10 July 2026

TfNSW reference: REN25/00089/003, SF2025/058640

SSD-77527735, Mangoplah Battery Energy Storage System, 4178 Holbrook Road, Mangoplah NSW 2652; Response to Submissions

OSOM Route Assessment - Port of Melbourne  
 Mangoplah BESS  
 Swept Path Assessment - Rest Area 4

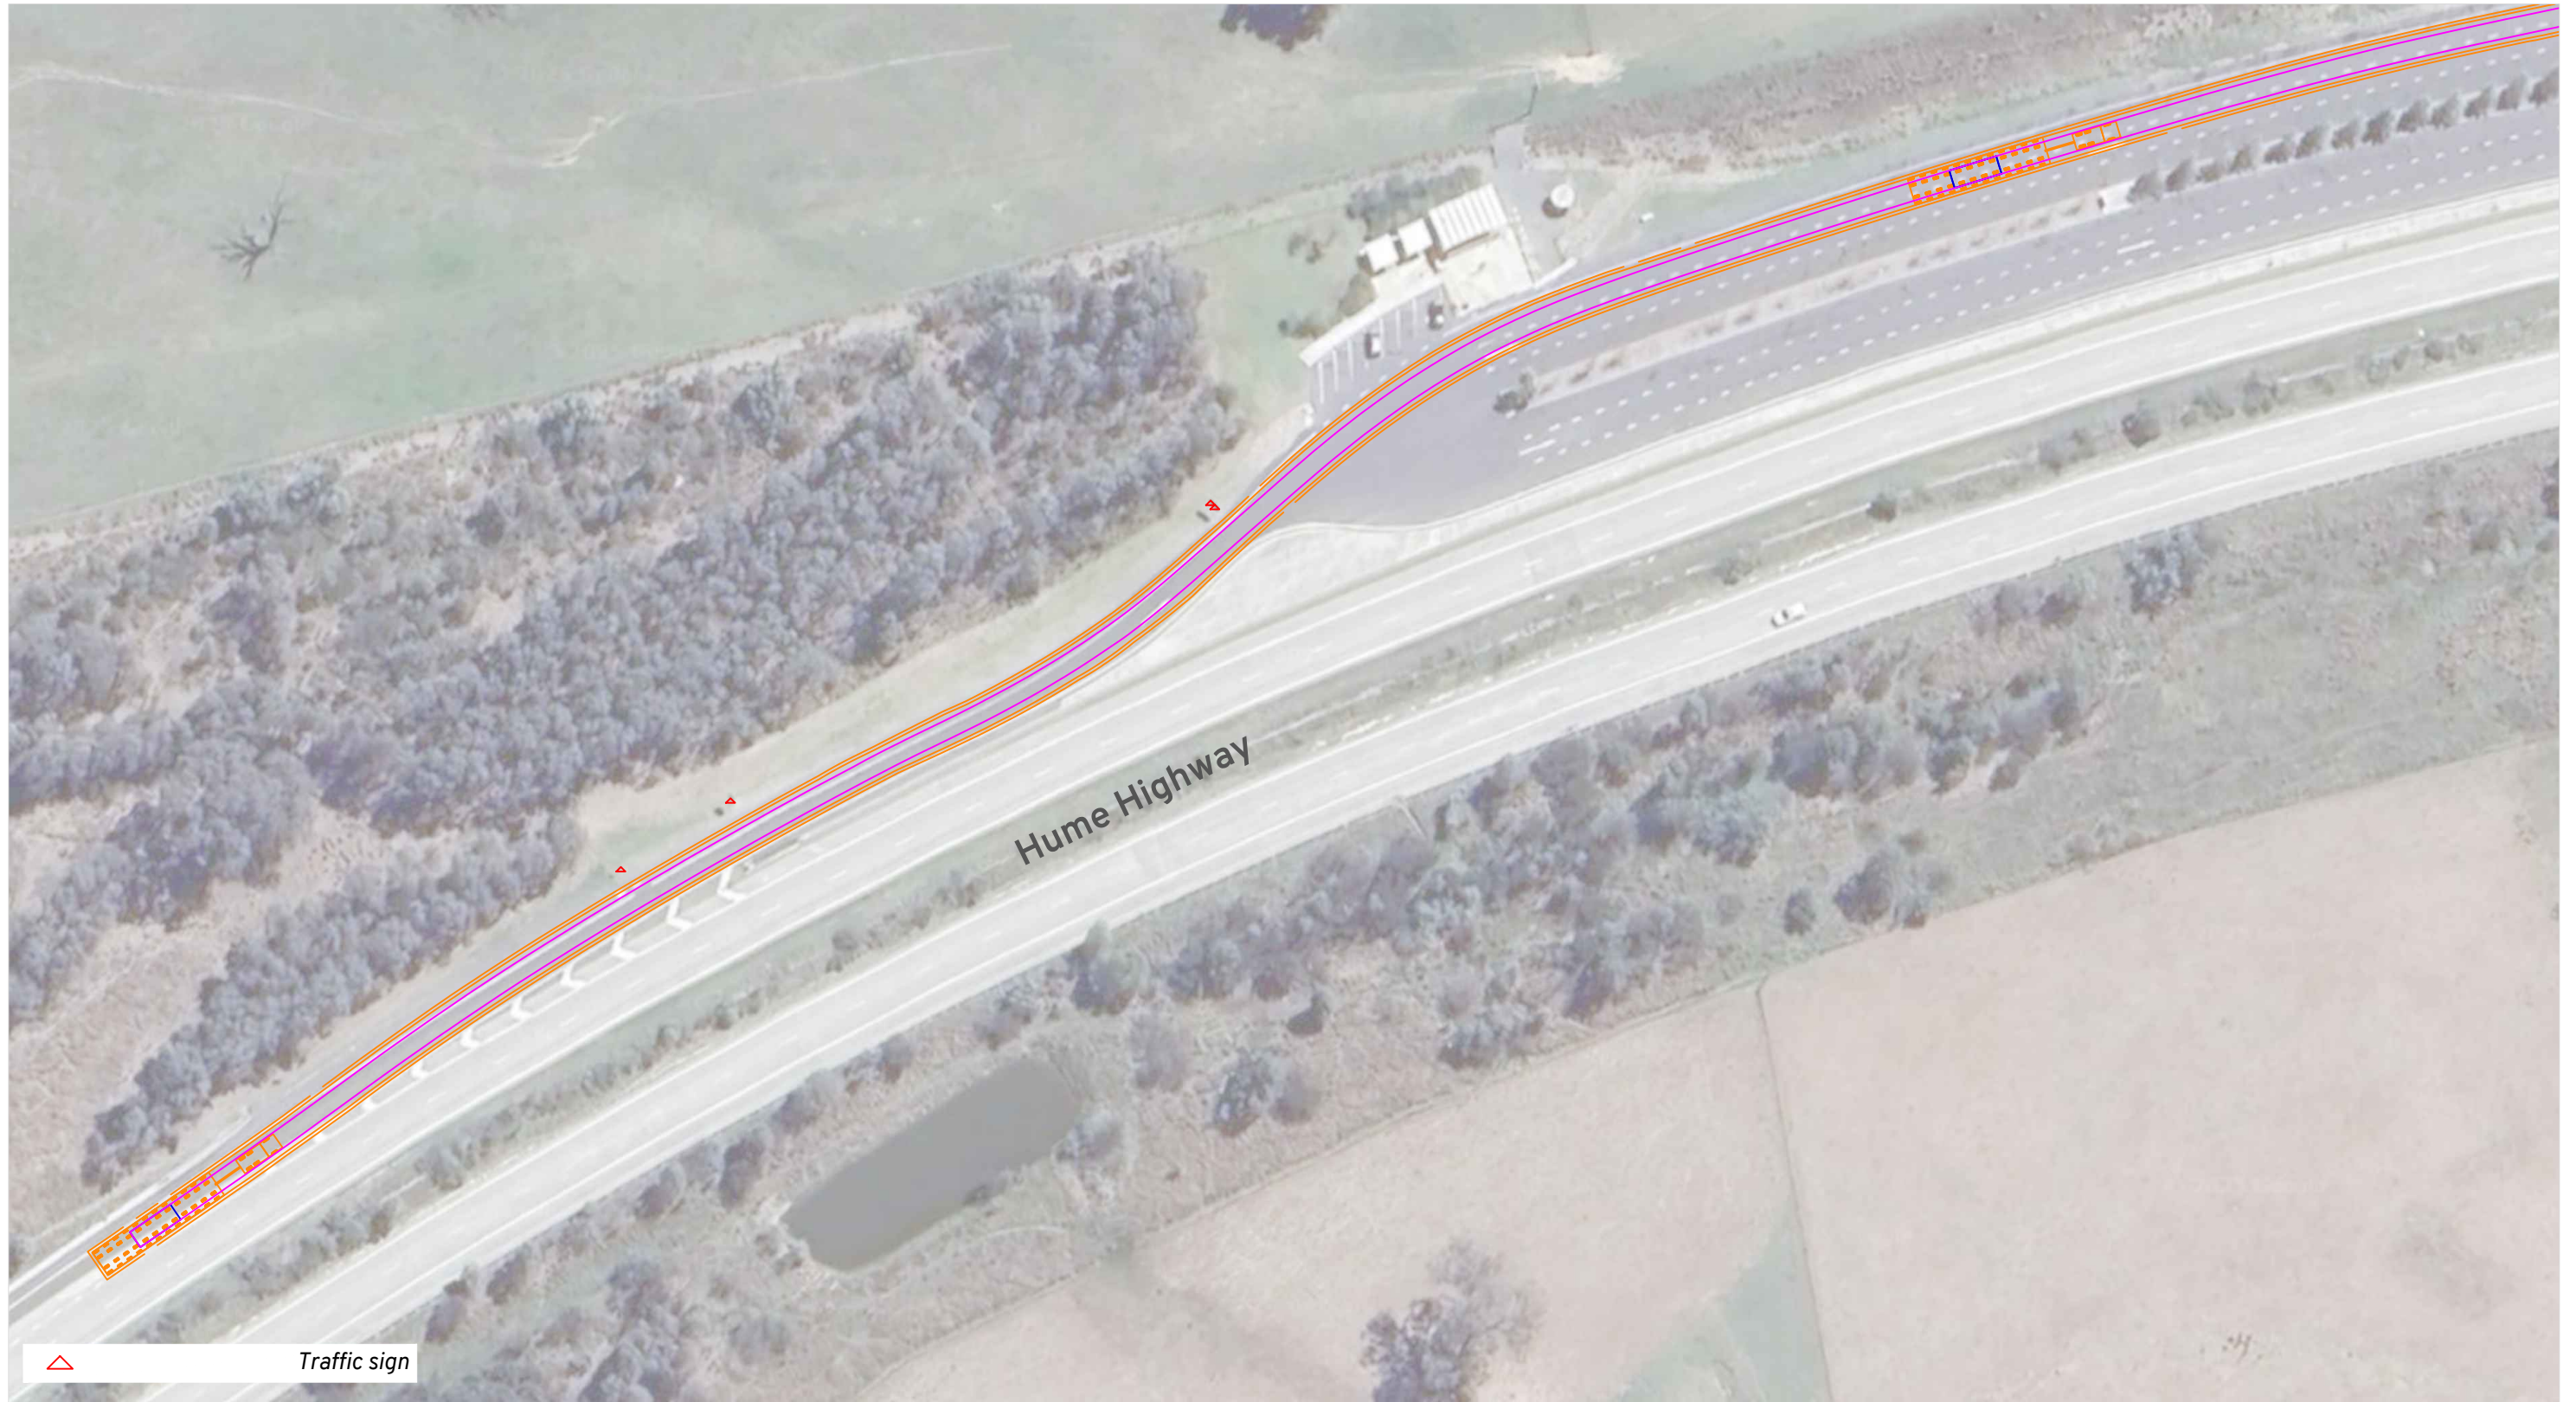
c.	The swept paths provided indicate that the OSOM traverses outside of the marked pavement at Rest Area 5 on the Hume Highway, see Figure 1. Swept paths are to be updated to demonstrate that OSOM movements can occur within the marked roadway, or strategic concept designs are to be provided with road and/or shoulder widening pavement	The swept path has been amended and refined, and the vehicle combination remains on the trafficable area of the road.	Noted.

Site Access

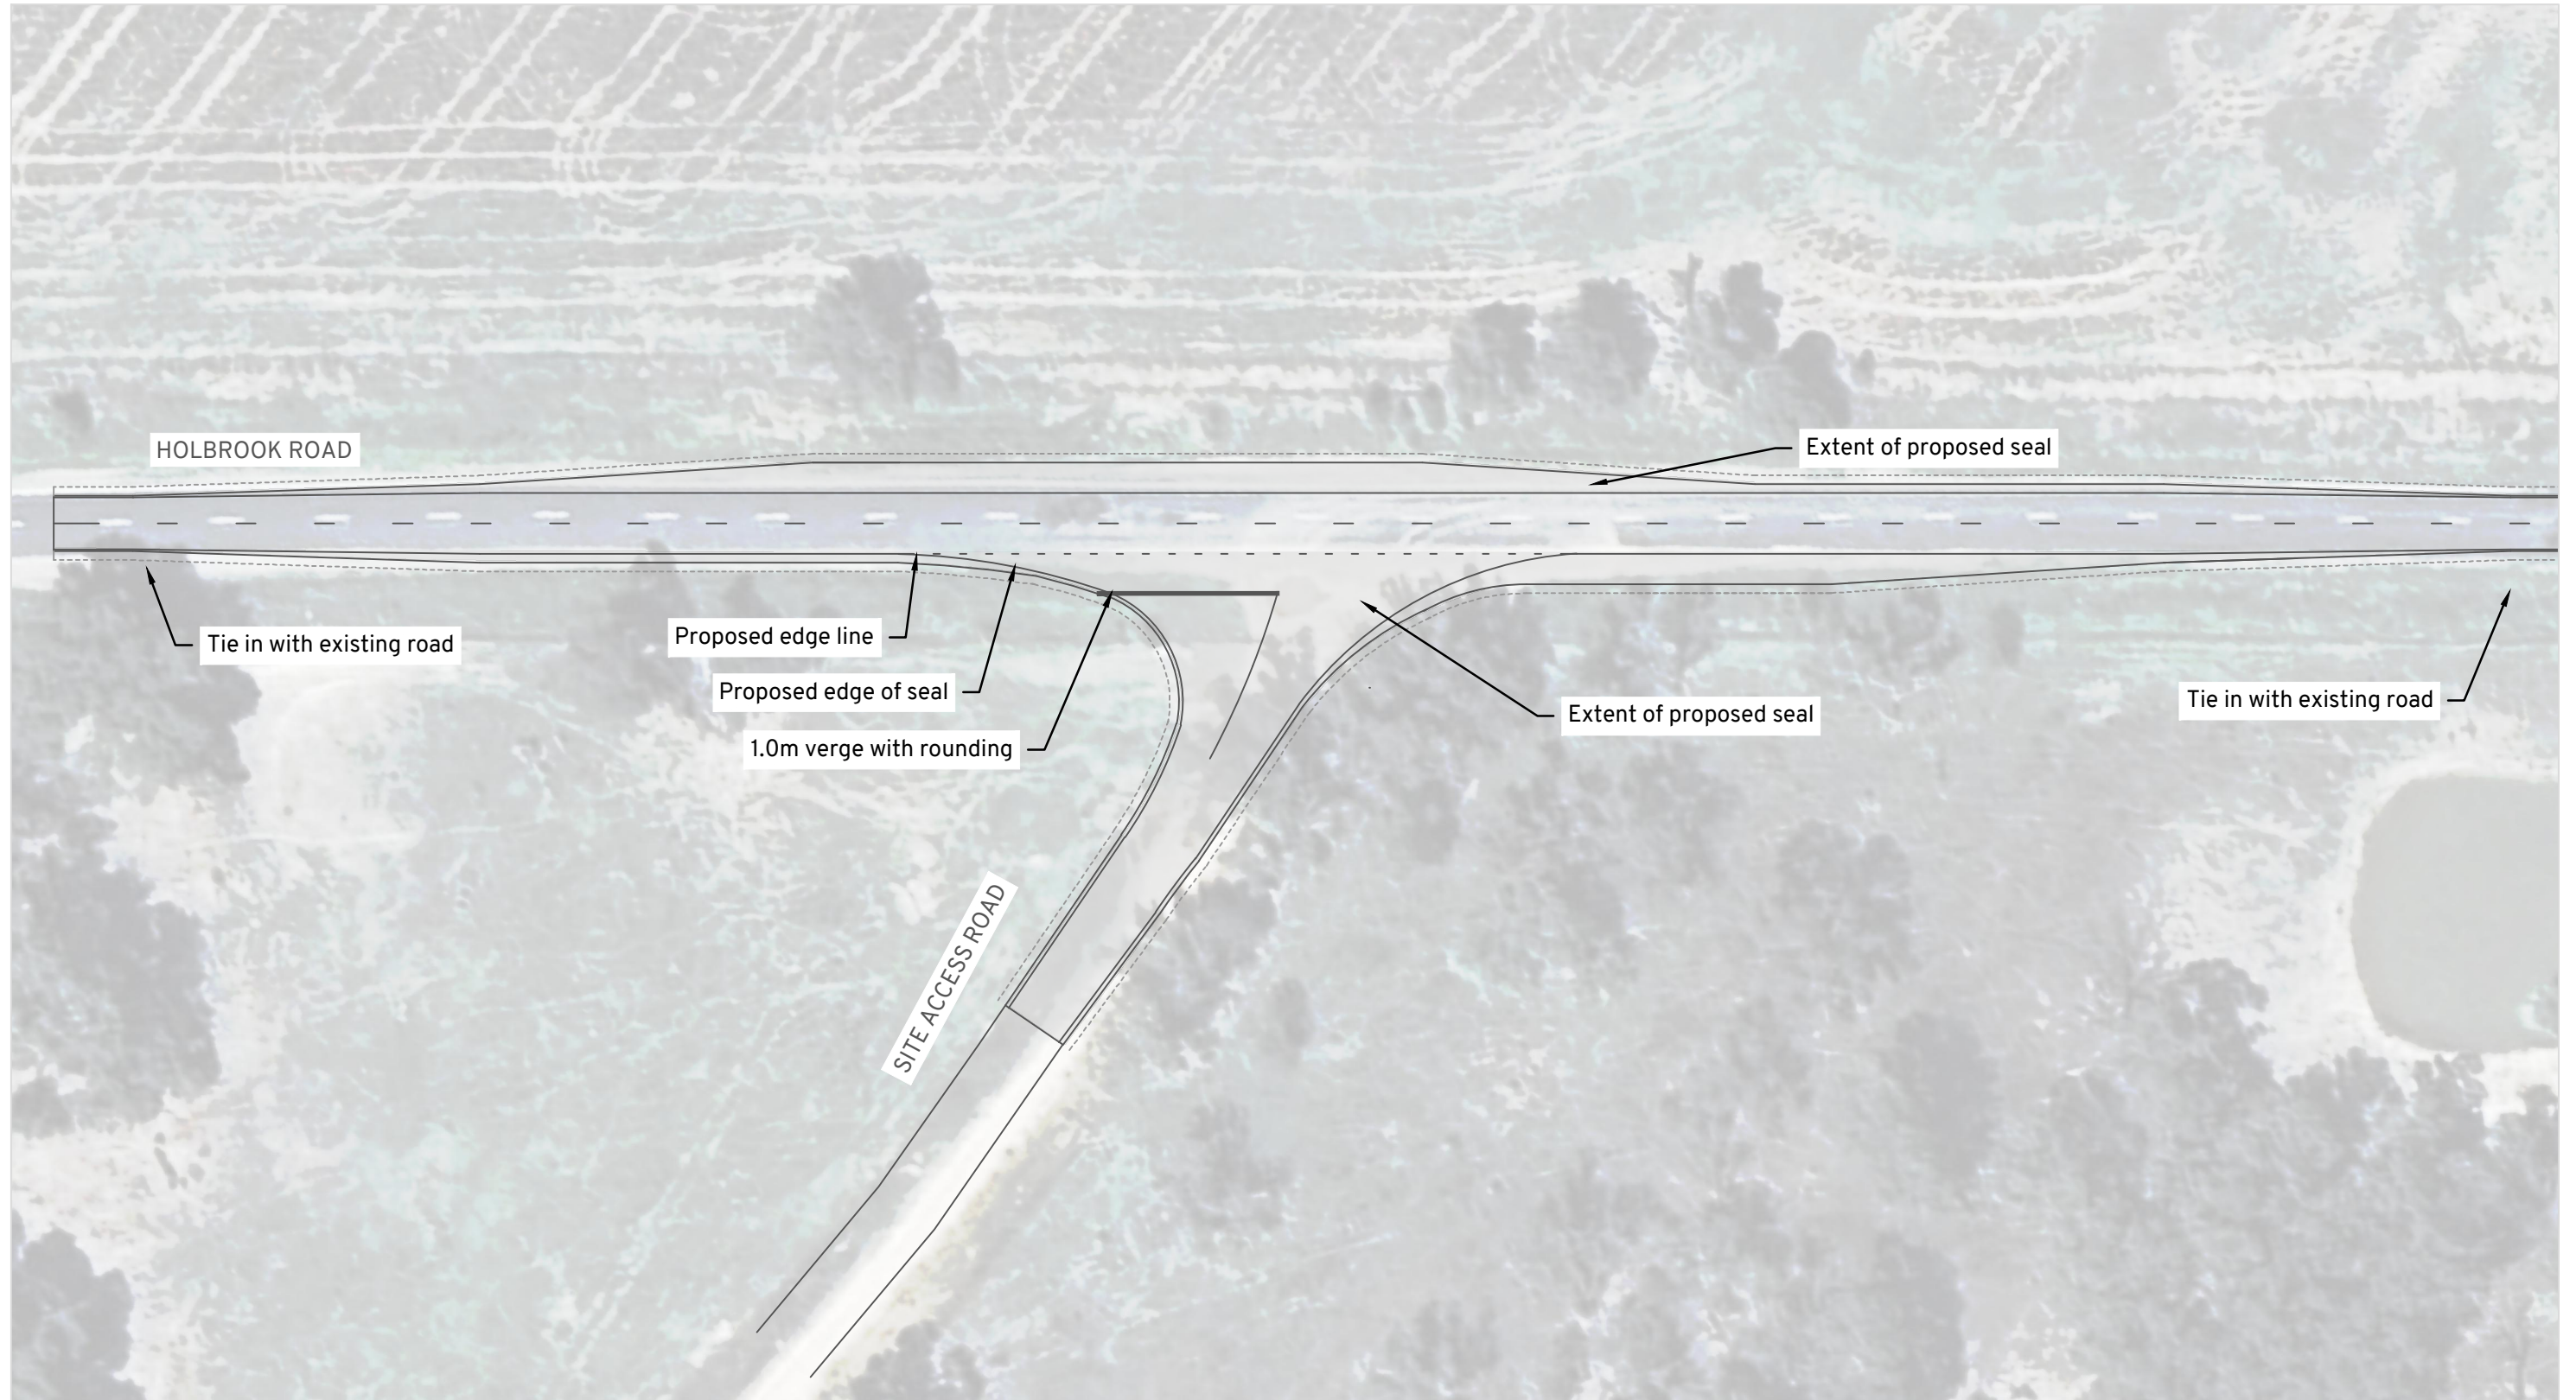
- Site Access Point on Holbrook Road – The final access strategic designs must demonstrate compliance with the relevant Austroads Guide to Road Design, applicable Transport for NSW (TfNSW) Supplementary Design Guides, standards and policies. The design must be submitted to and approved by the relevant road authority prior to the commencement of any associated works.
